Your ref: H04/0152/06
Our ref: 641 2 LMS VJA

24 July 2006

**GEORGE BARNSDALE AND SON
DEMOLITION OF STORE AND ERECTION OF A JOINERY PRIMING
WORKSHOP (NECESSITATING THE DIVERSION OF PUBLIC
FOOTPATH)
LAND OFF HIGH STREET, DONINGTON**

rdc Robert Doughty Consultancy			
Client: George Barnsdale & Sons			
Project: High Street, Donington			
Drawing title: Proposed Workshop			
Job No. 641-2	Drawing No. DS01	Rev. C	Drawn KTC
Scale 1:100	Date 04-01-06	Checked

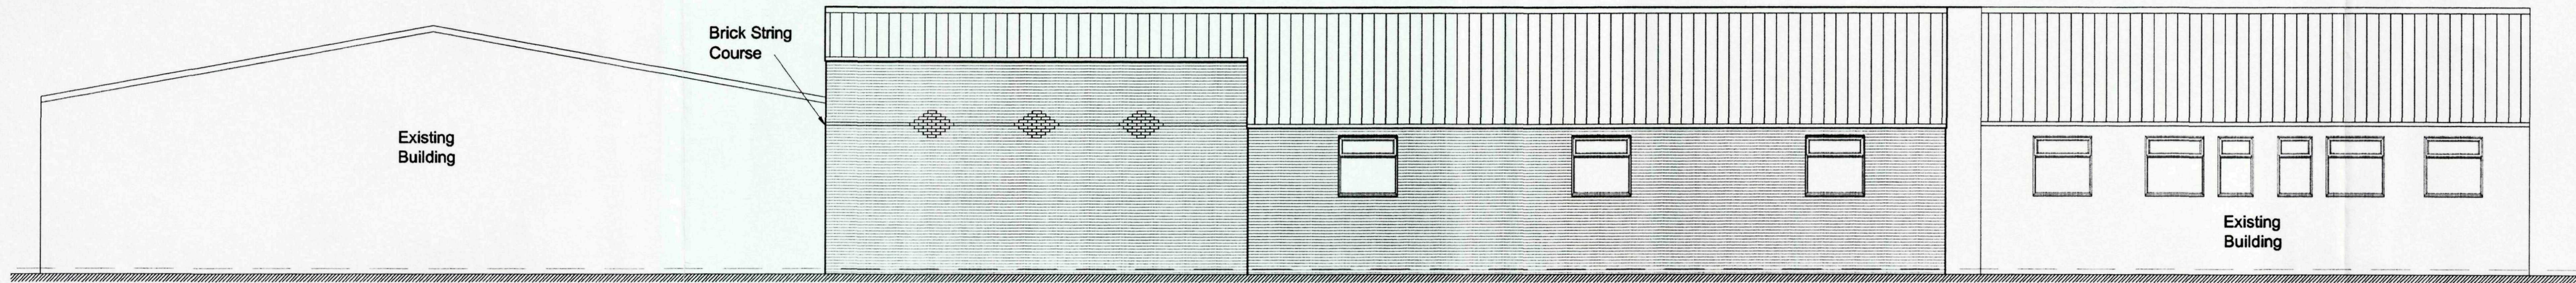
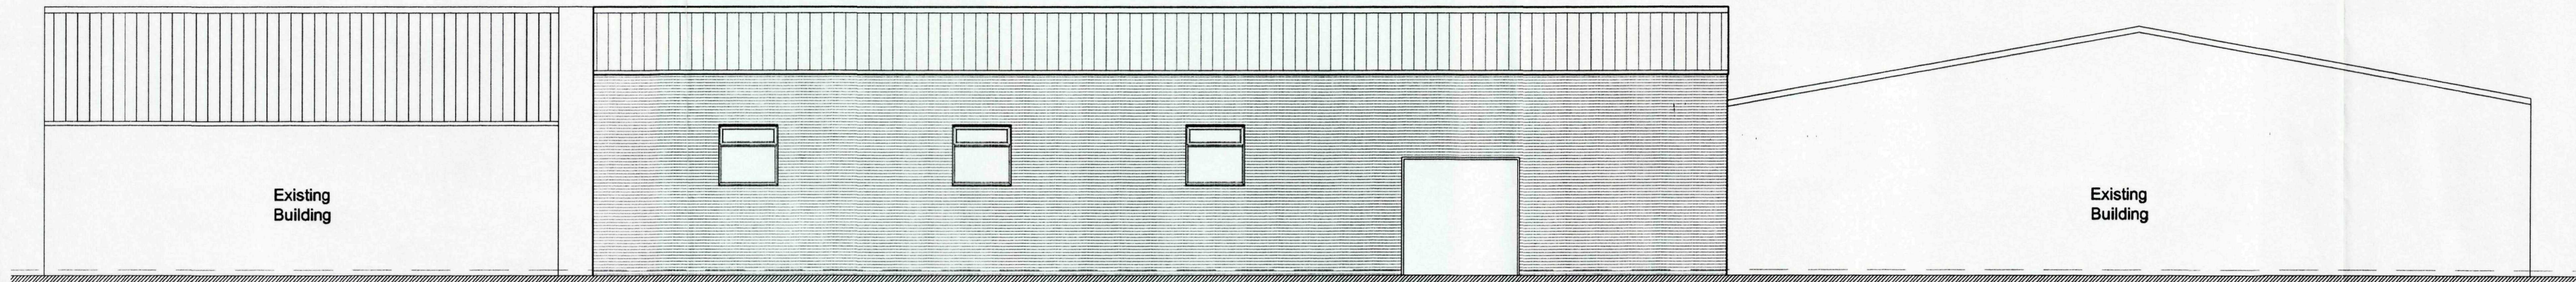
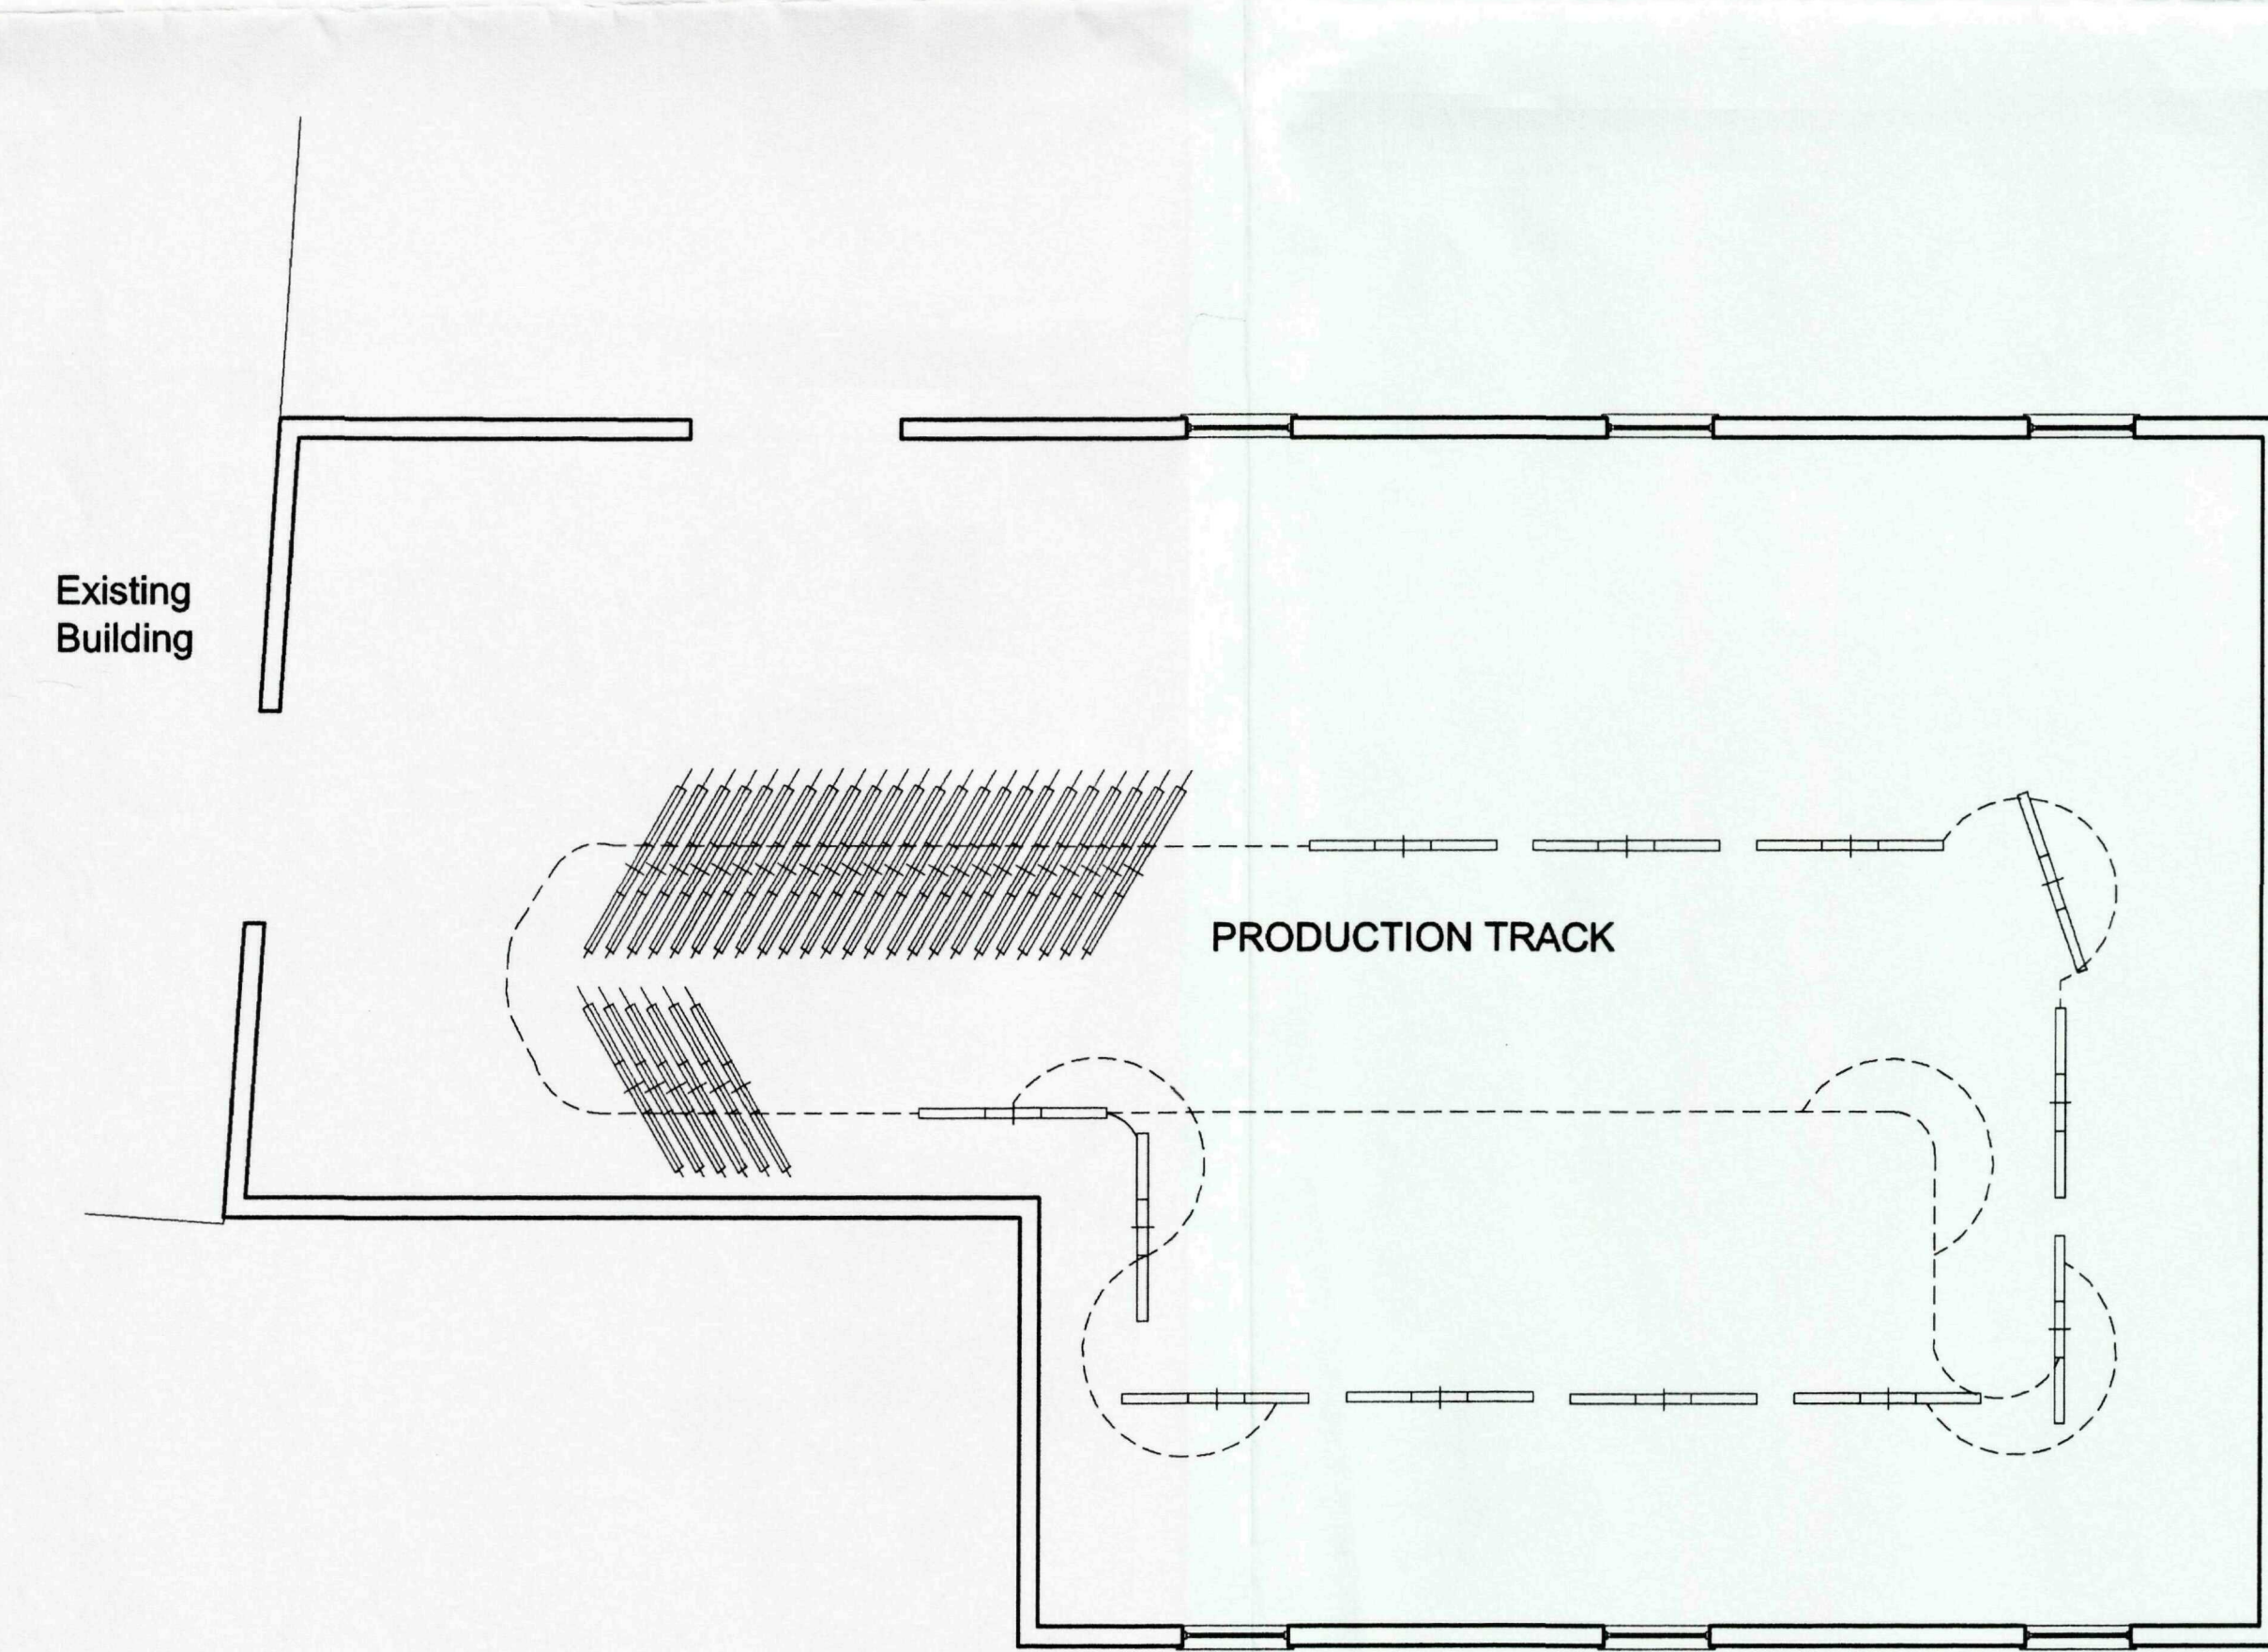
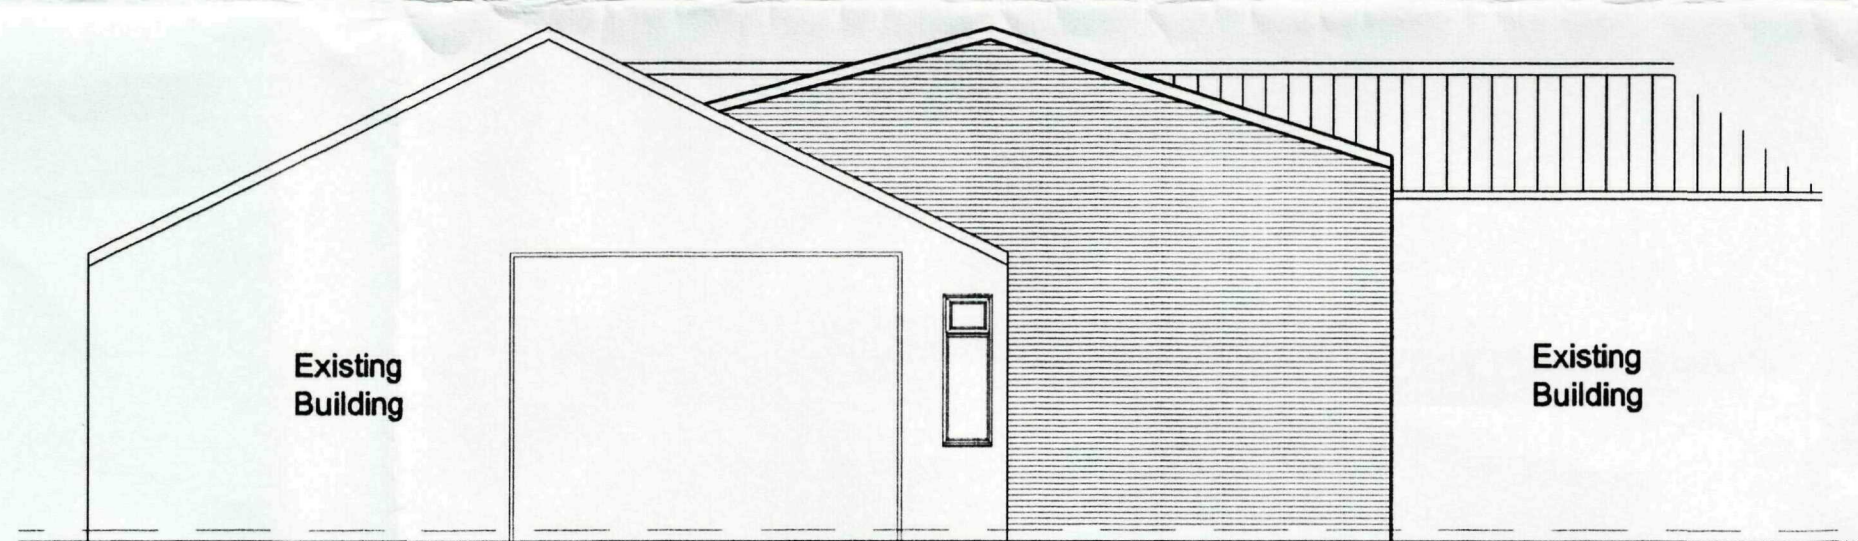
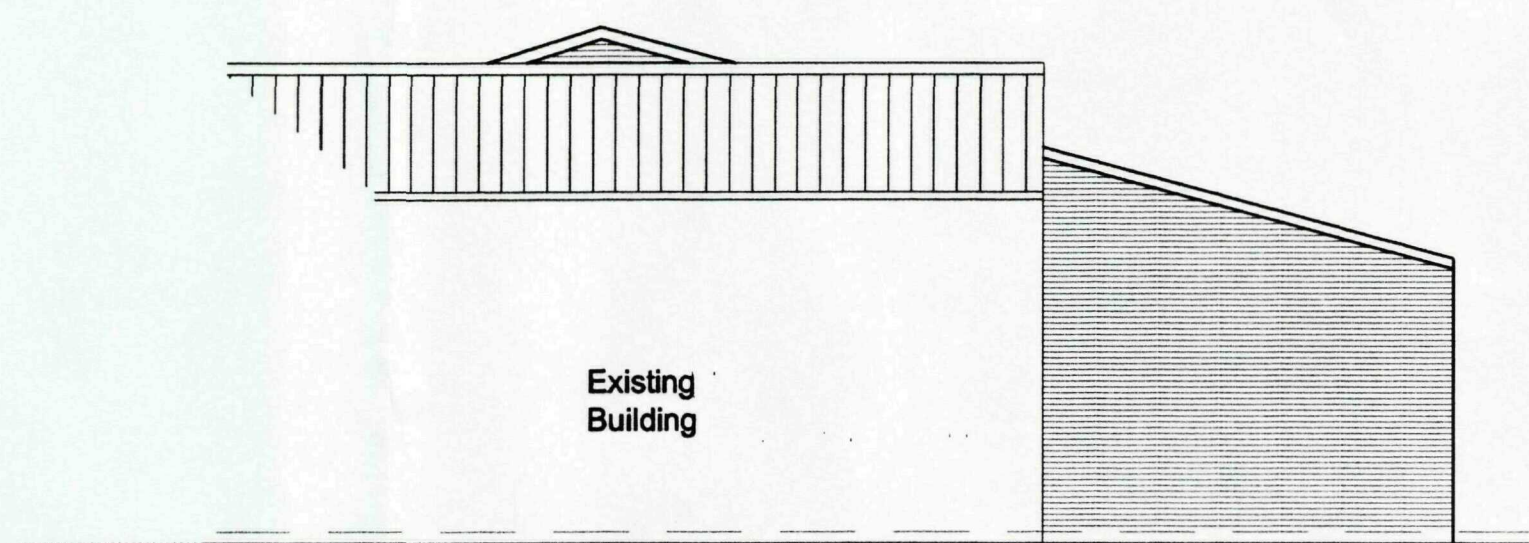
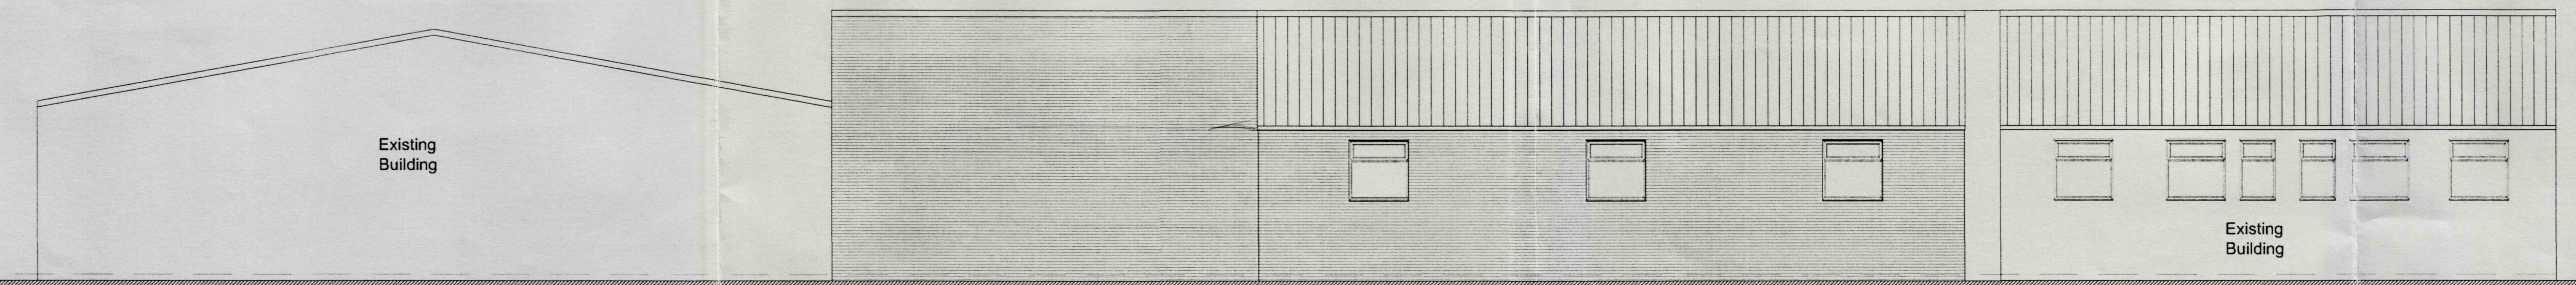
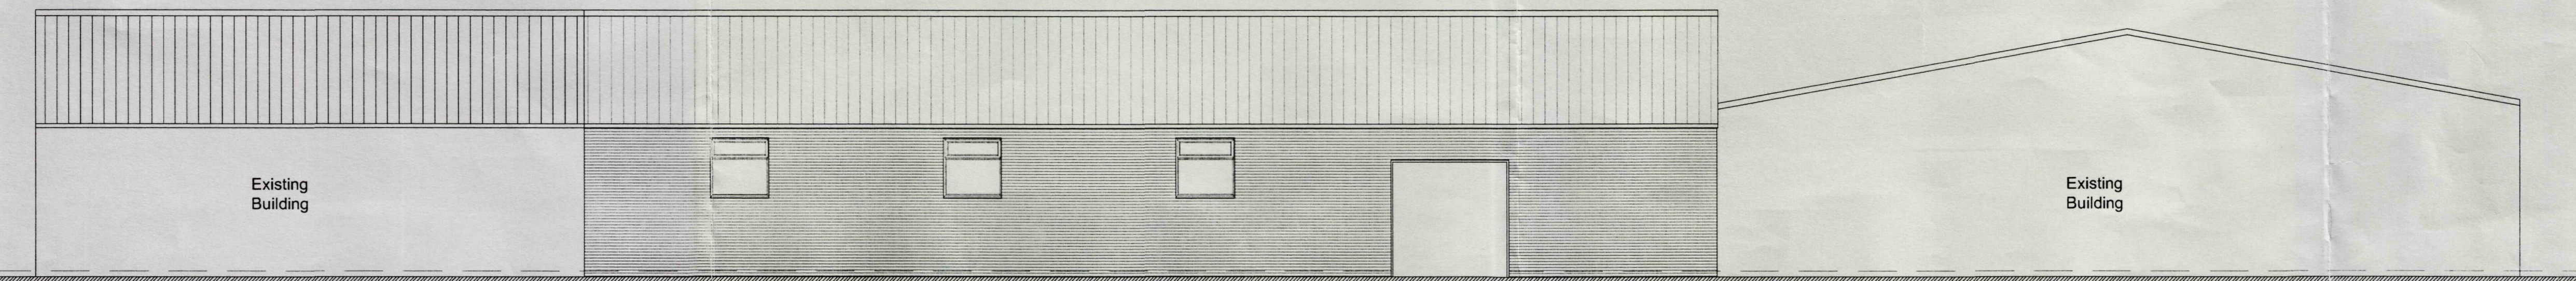
We have changed the roof pitch to reduce the amount of brickwork on the western elevation of the workshop that is visible from the Public Footpath. In addition, we have added some relief brickwork to break up the façade.
